From: David Fuller [REDACTED]
Sent: 17 June 2015 11:01
To: Ross Leal
Cc: Sophie Masson; AFA Fuller
Subject: Russet House - K/17/15/HH - Response to objections

Job Title	
Russet House, Kingston Gorse	
Client	
Miss S Masson	
Drawing Name	
Driveway & Landscaping Plan	
Drawing Status	
Planning	
Drawn by	DF
Date	June 15
Checked by	Date
Drawing Scale	
1:100 at A1	
Drawing No	Status Revision
15753/ 07

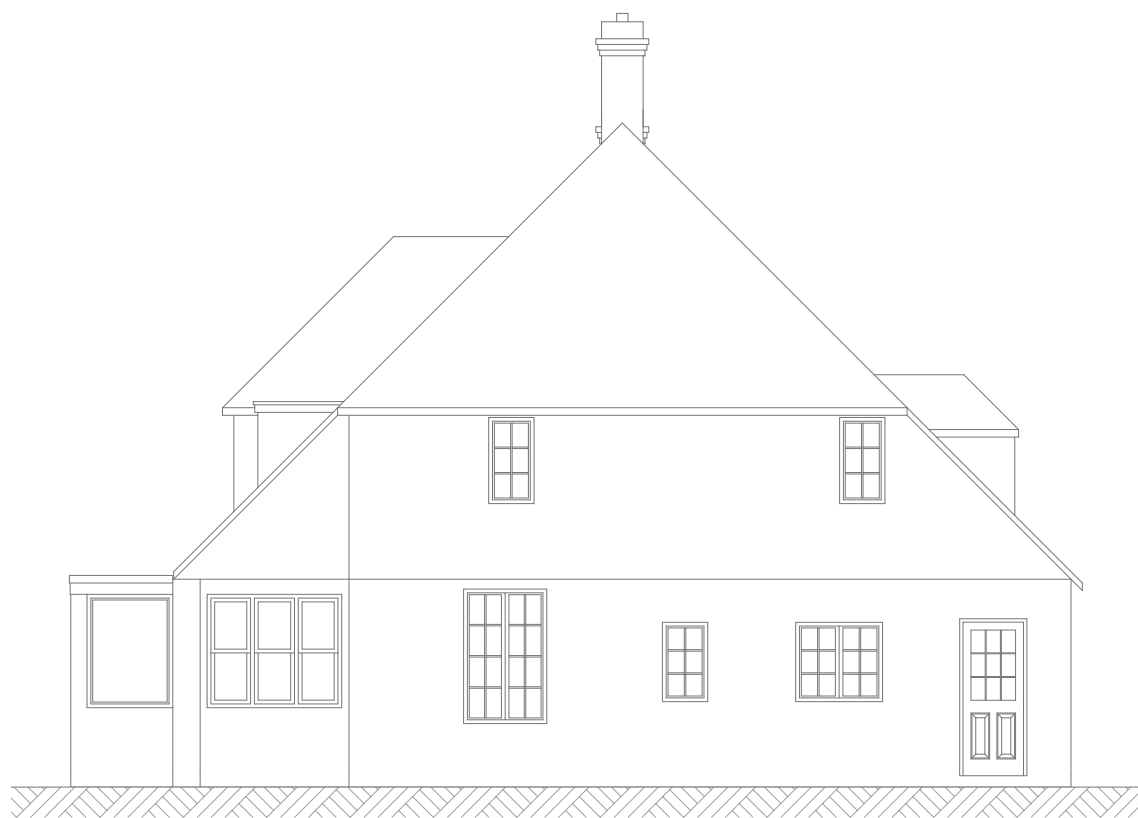
- 3) Mr & Mrs Bridgwater - The Dutch House (Immediately to the Northeast of Russet House) - have objected to the speculated enlargement of the driveway entrance to Russet House. Please see the attached drawing number 15753/07, detailing the driveway, landscaping and boundary treatments. We hope this will alleviate Mr and Mrs Bridgwater's concerns, as the driveway is only slightly enlarged from that of the existing opening, however is recessed and is similar to what they have created at The Dutch House. Just to confirm, the recessed driveway will be advantageous from a highways perspective as it will allow vehicular movements in and out of Russet House to be achieved without the creation of risk to those traversing along Downsview Road. Furthermore, the additional parking provision from the enlarged internal driveway, will eliminate any necessity for parking on Downsview Road, and will improve manoeuvrability.

Drawing Name
Proposed Ground Floor Plan

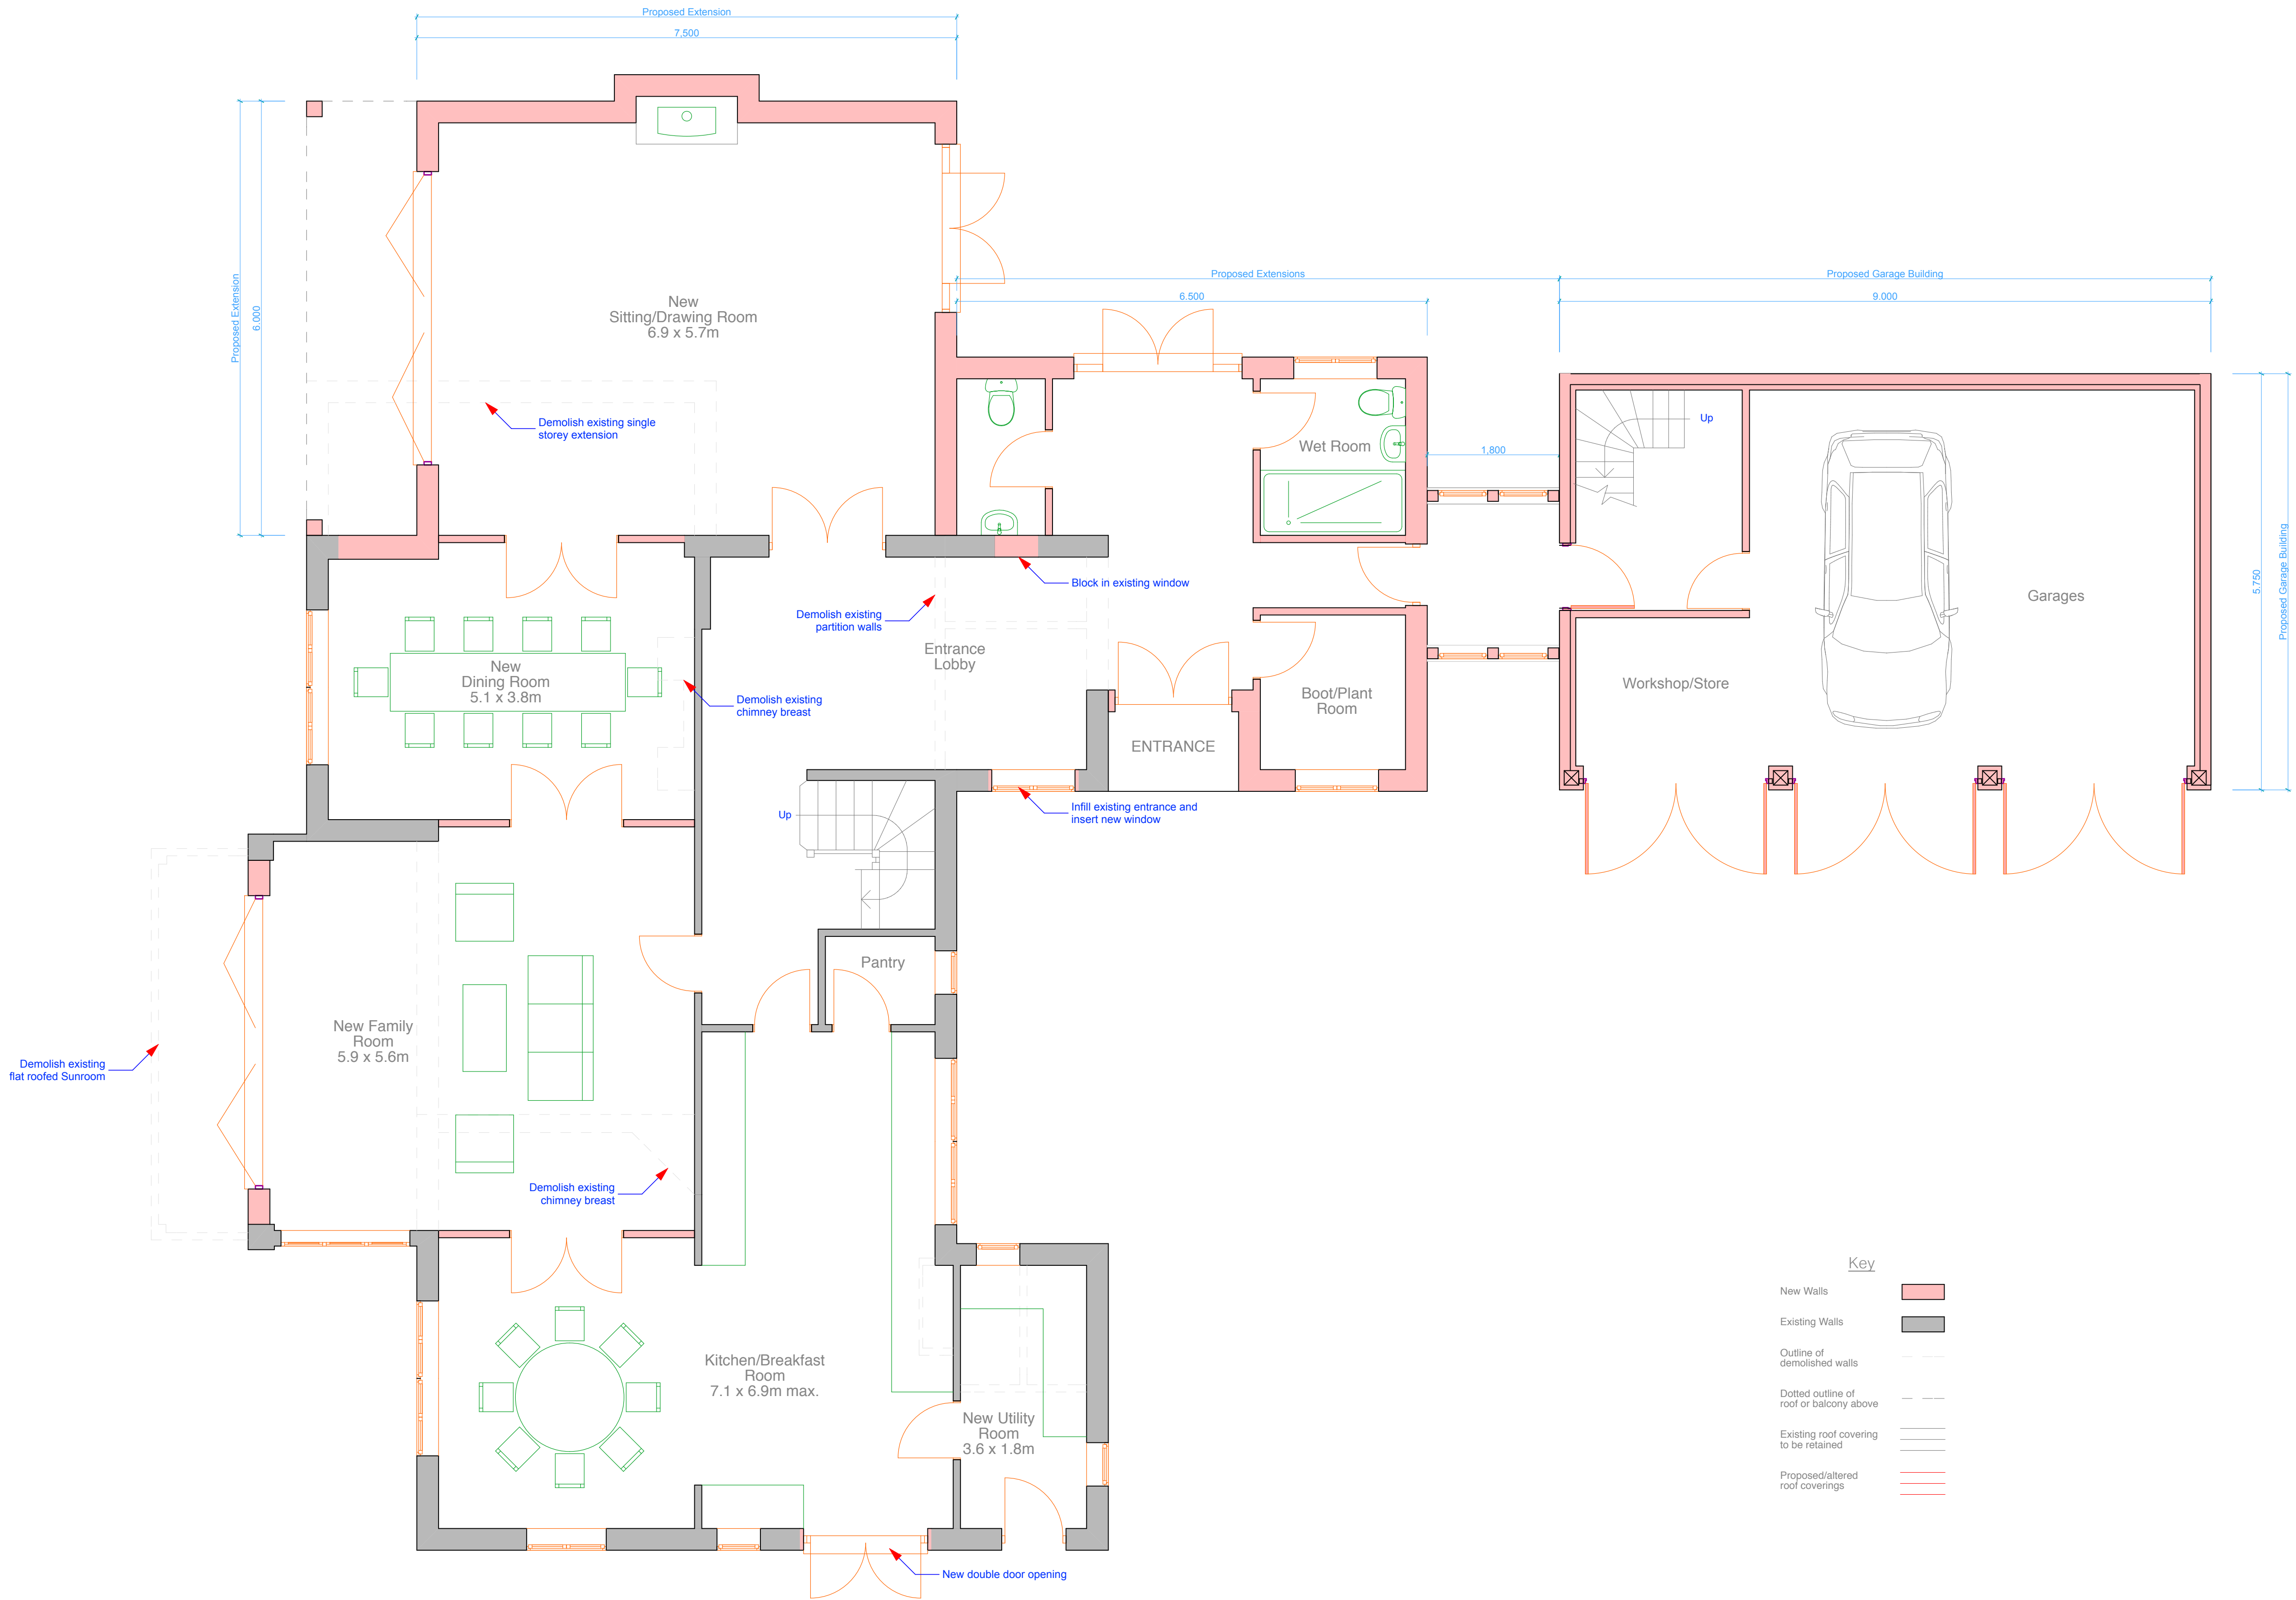
2) The massing of the Garage building and corresponding roof shapes are to be subservient to the host dwelling, in an attempt to minimise the impact visually to the surrounding properties, whilst creating adequate habitable space internally. The proposed Garage is to provide 2 parking spaces only, and does not increase the parking provision from that of the existing dilapidated Garage. The proposed Garage seeks to provide an aesthetically enhanced building in shape and form, from that of the existing unsightly flat roofed building, by utilising a pitched roof with Sussex Barn Ends. Furthermore this is a family dwelling and is to be used as such, and therefore we feel there would be no exacerbation of accident risk in Downsview Road. There are also mature hedges of considerable height on Russet House's Eastern boundary, which means that much of the garage building will not be visible from Downsview Road.

3) The proposed swimming pool is well shielded from the objecting property by the proposed link extension and Garage building. In addition, fencing and hedging/tree foliage will provide additional shielding from any noise nuisance that may arise. Also, as Mr and Mrs Millet mention in their letter, many of the properties immediately surrounding Russet House have outdoor swimming pools - they are an established feature of the area.
